AENC-NG-CNS-REP-0208

Norwich to Tilbury

Document: 8.1 Errata List

Planning Inspectorate Reference: EN020027

Revision: A

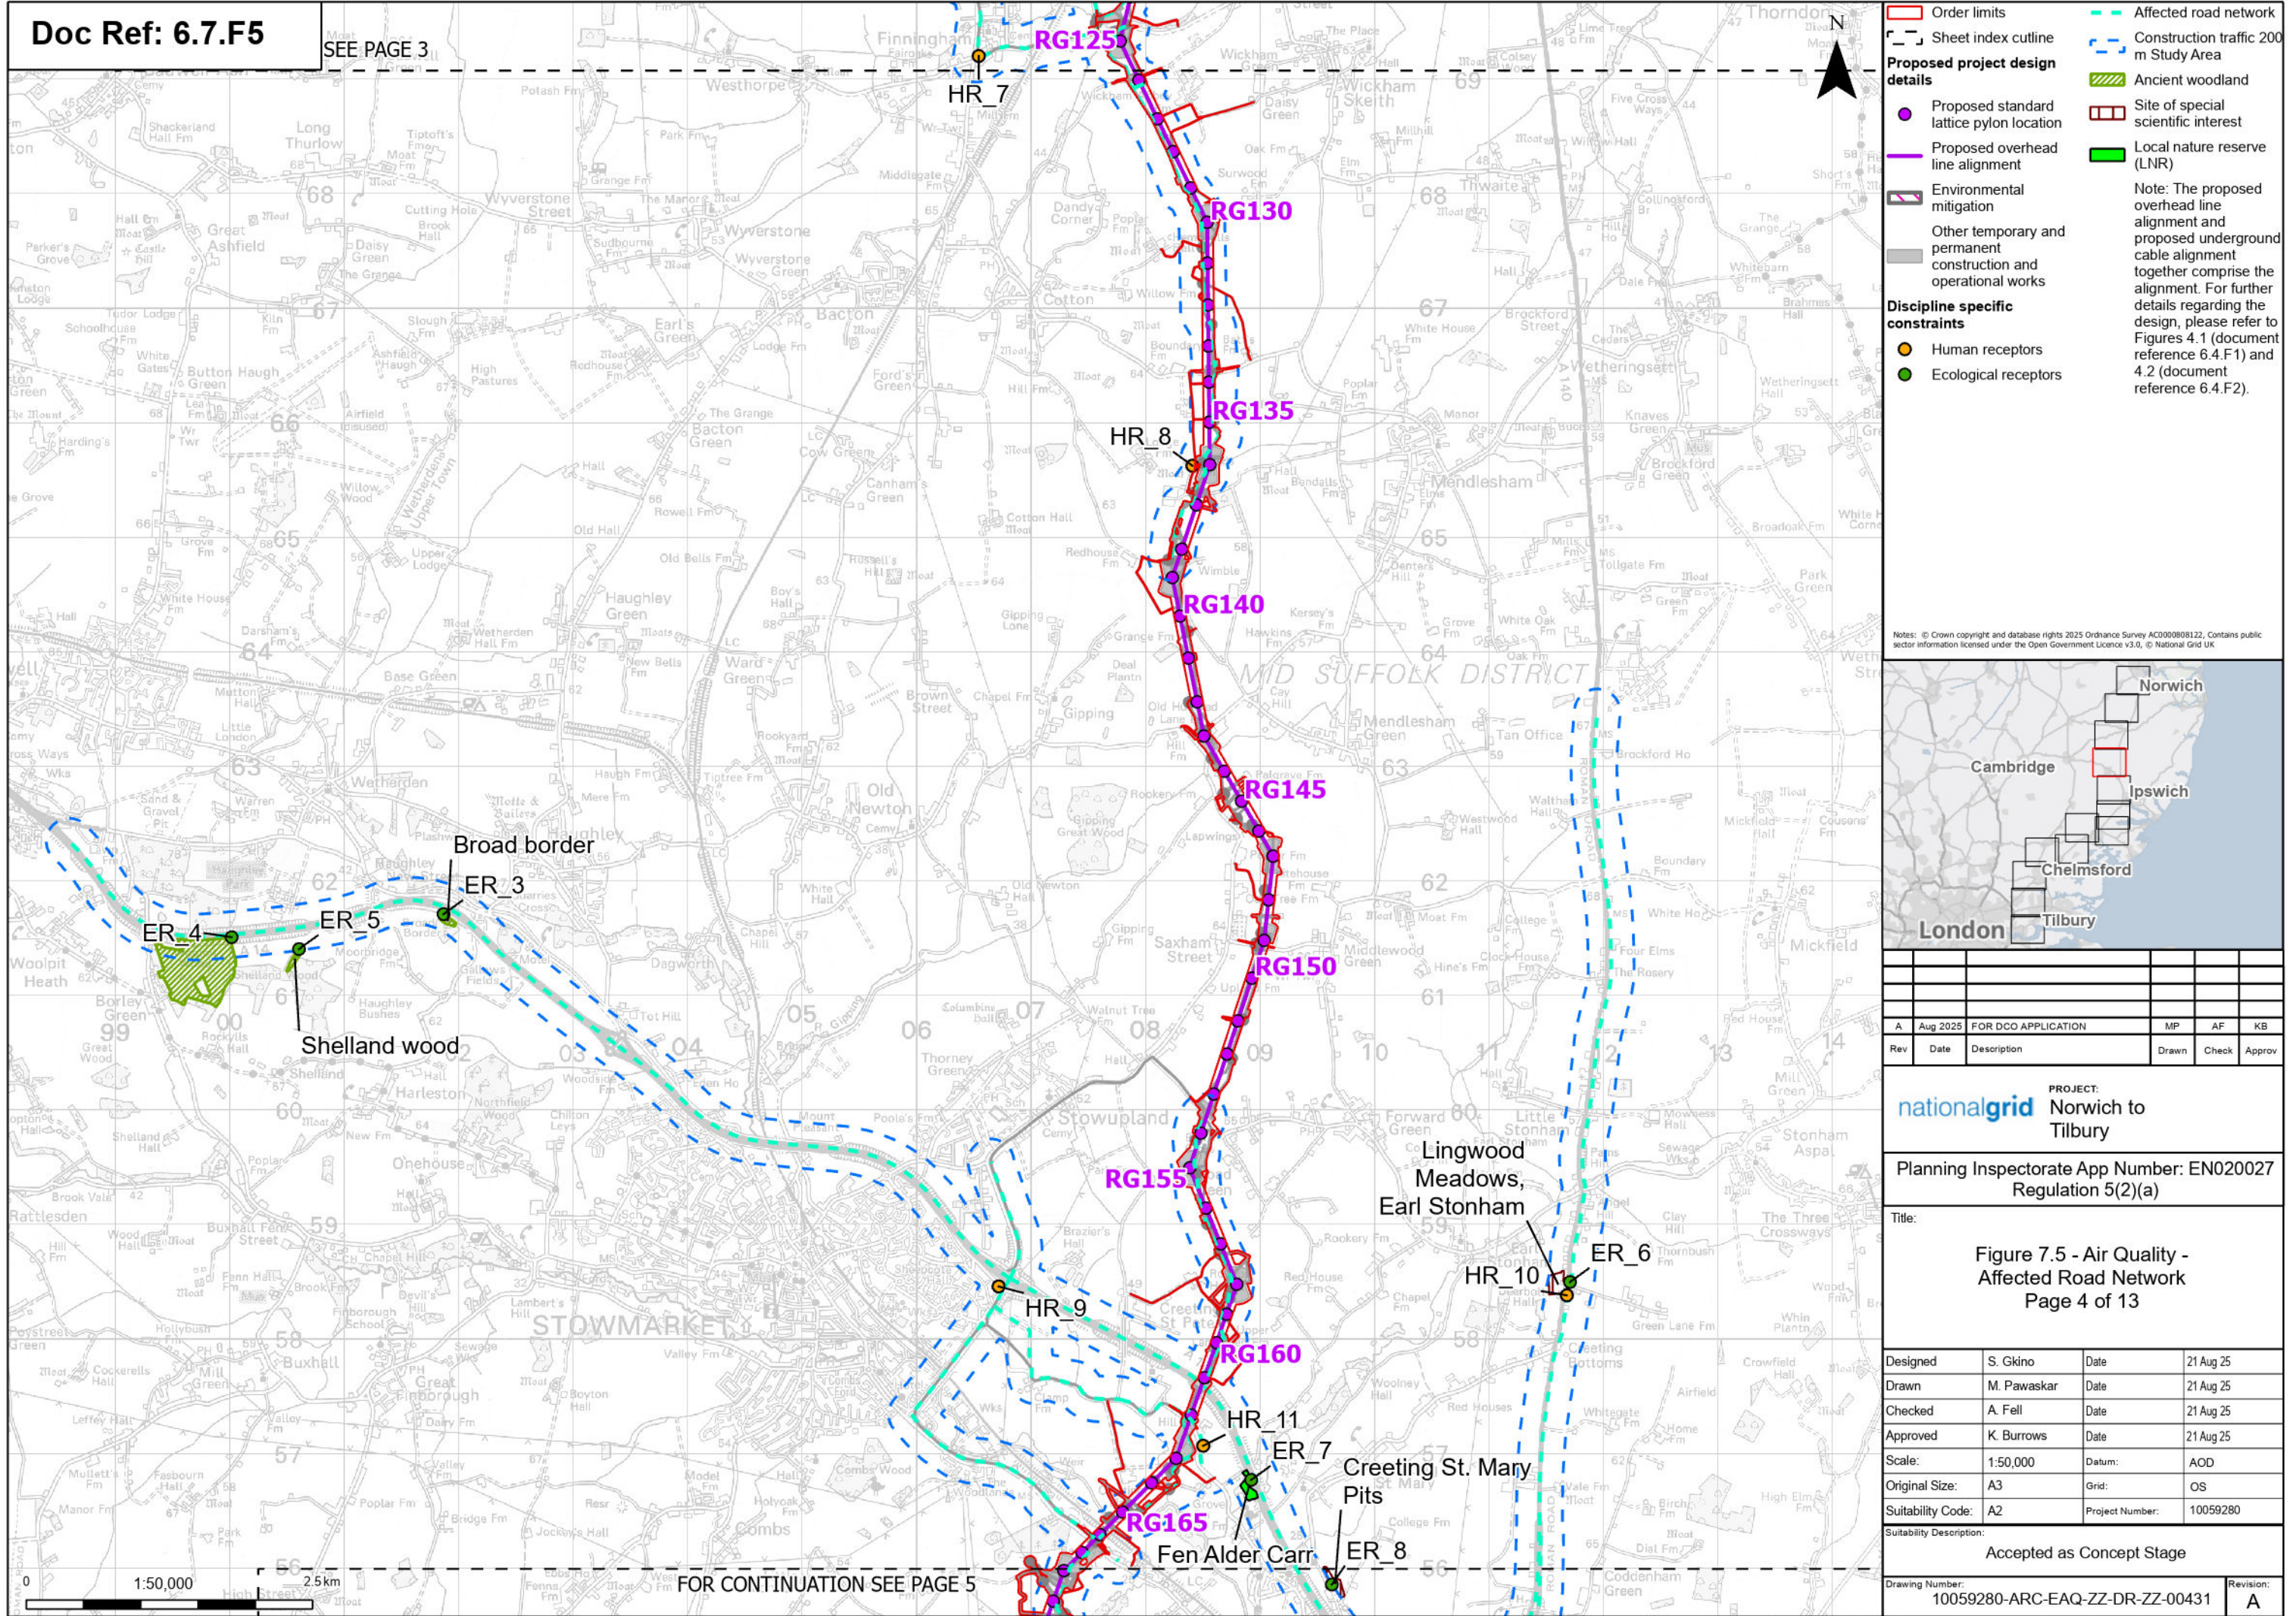
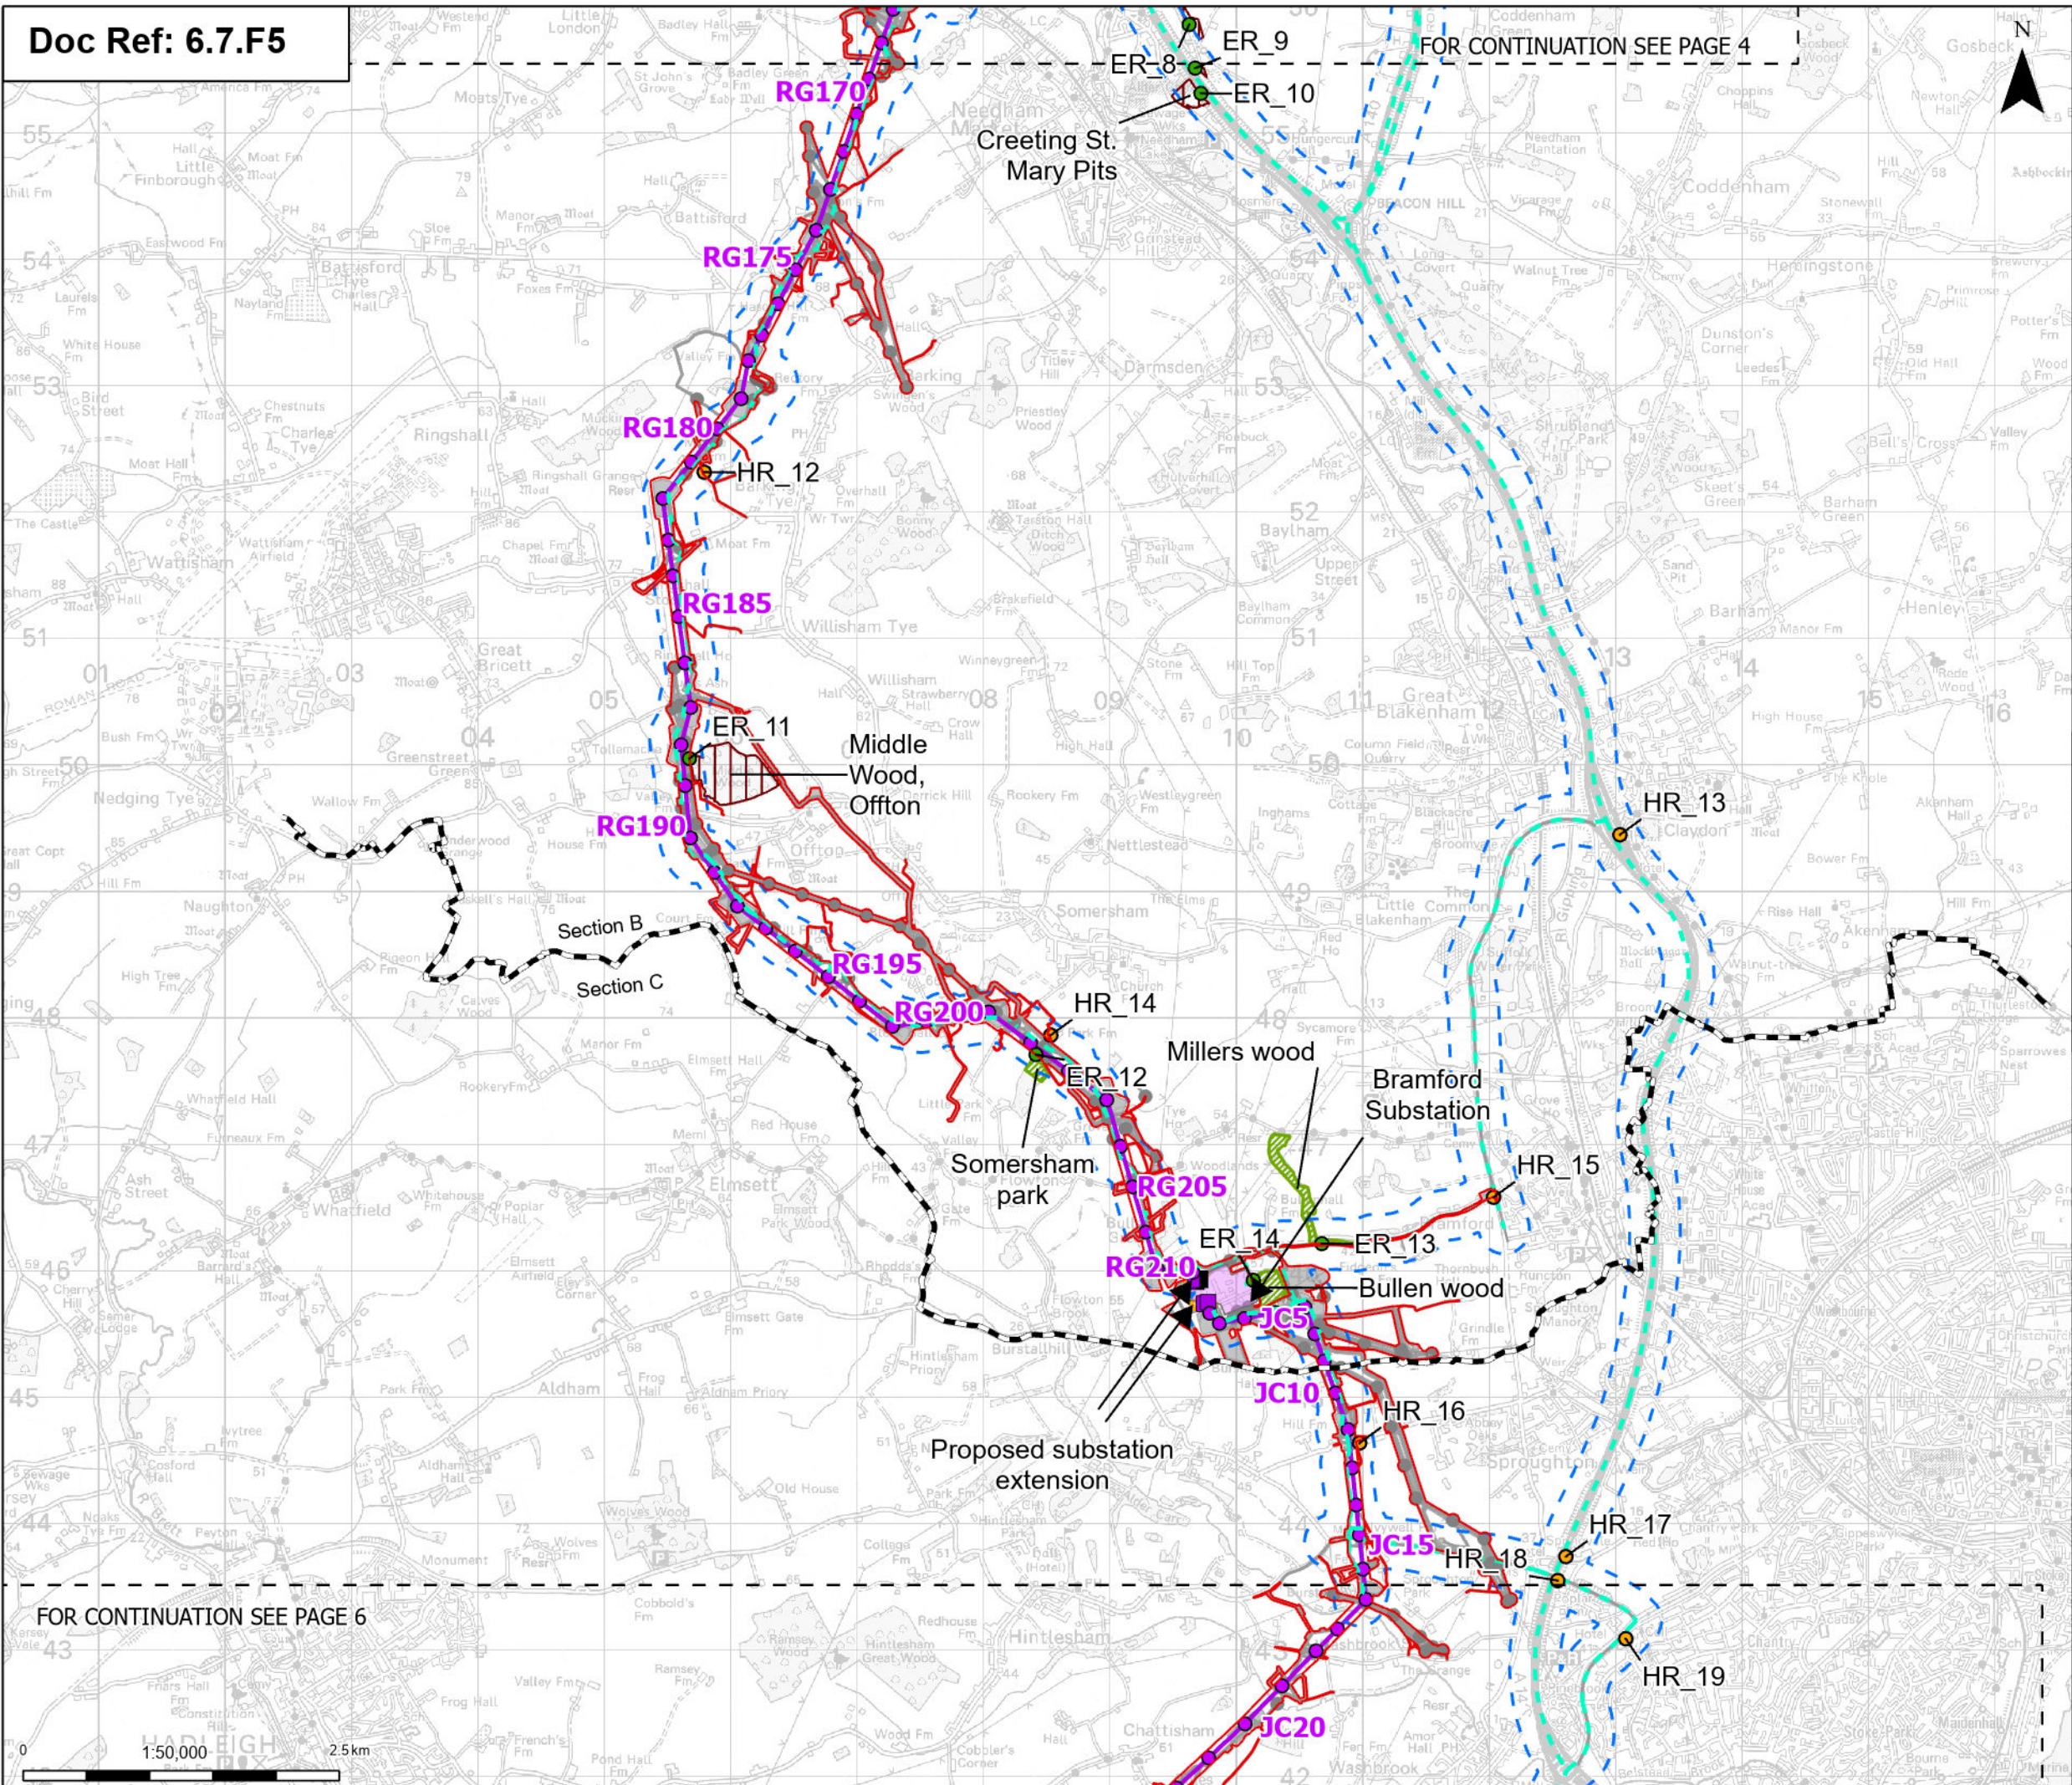
6.7.F5	Environmental Statement Figure 7.5: Air Quality – Affected Road Network	N/A	Duplicated dataset layer included within Figure.	Dataset ‘Project_Defined_AW_2’ is presented in error within the Figure. All data is included within the ‘Ecological receptors’ dataset. Therefore, the ‘Project_Defined_AW_2’ dataset should be ignored and ‘Ecological receptor’ dataset should be relied upon.
